# LANDSCAPE PLAN

BIG O TIRES  
6985 N. MERIDIAN RD.  
PEYTON, CO 80831  
EL PASO COUNTY, COLORADO

SHEET NO.  
8 OF 11

Project file No. PPR1836

SHEET NO.
8 OF 11

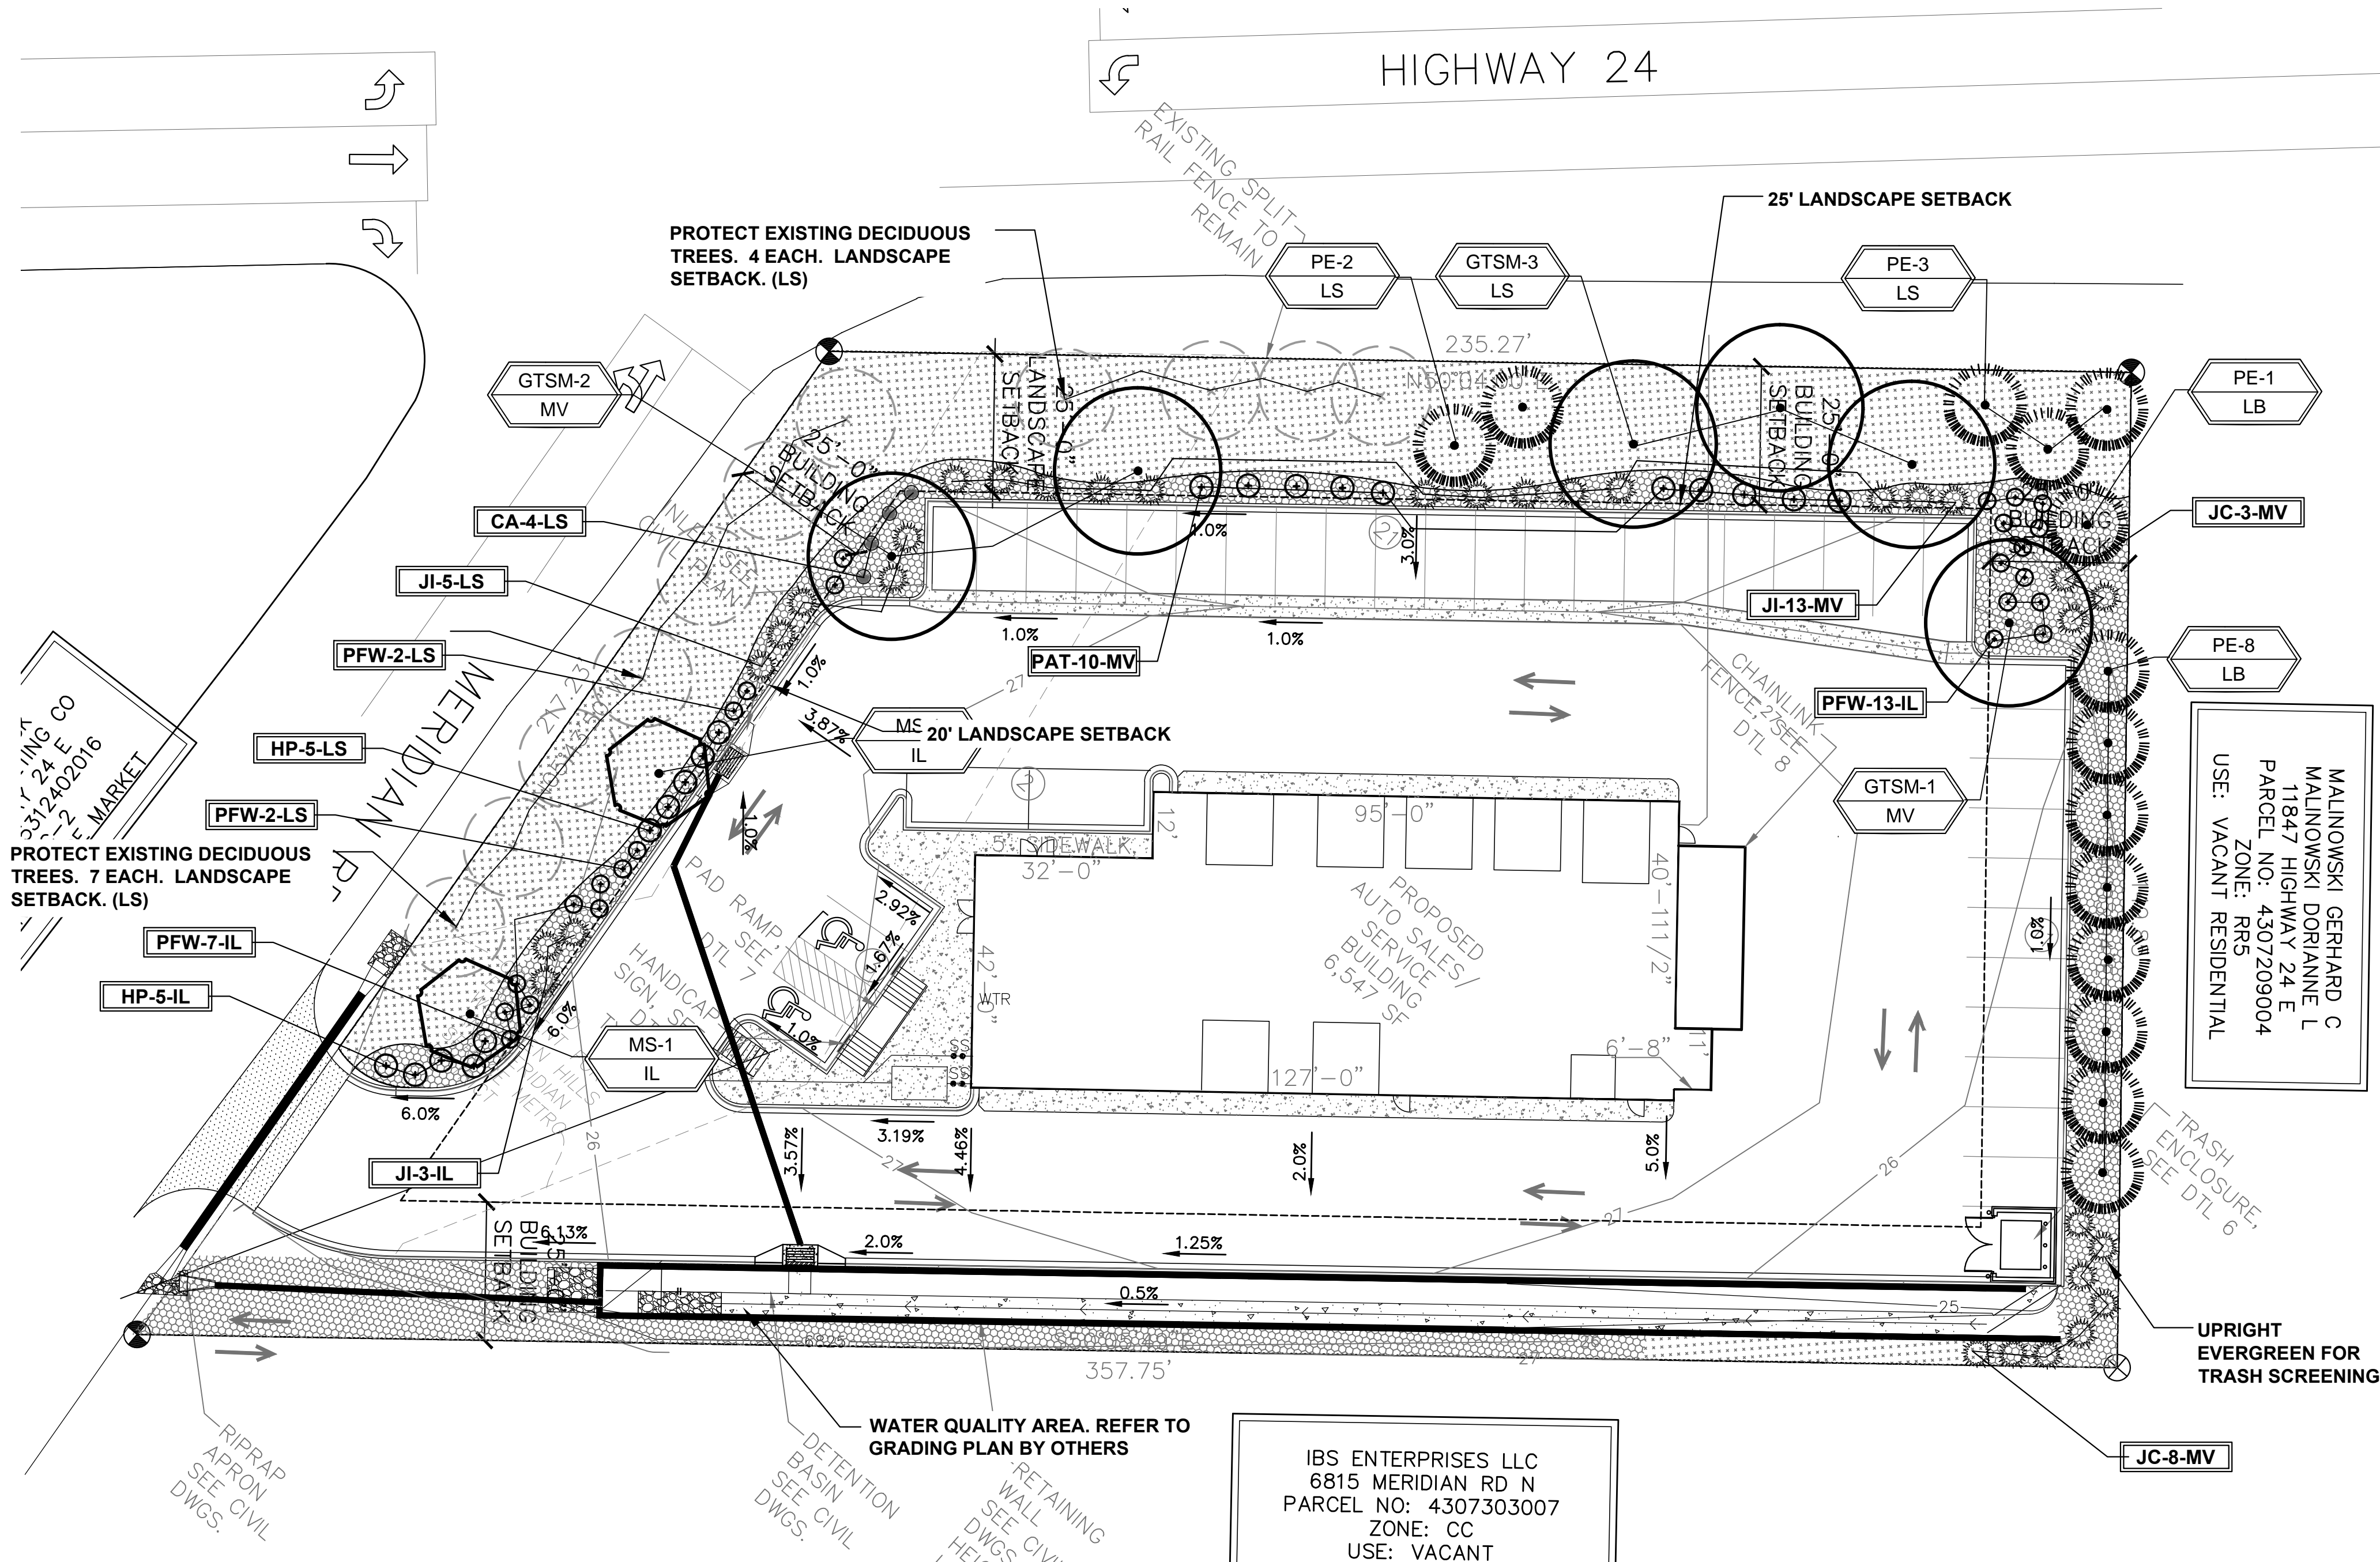
Include Meridian Rd.

Need fingers or islands.

Add internal landscaping. 5 Trees necessary

15' Buffer Required, or request alternative landscaping. 1 tree per 25' of common lot line. - 6 trees.
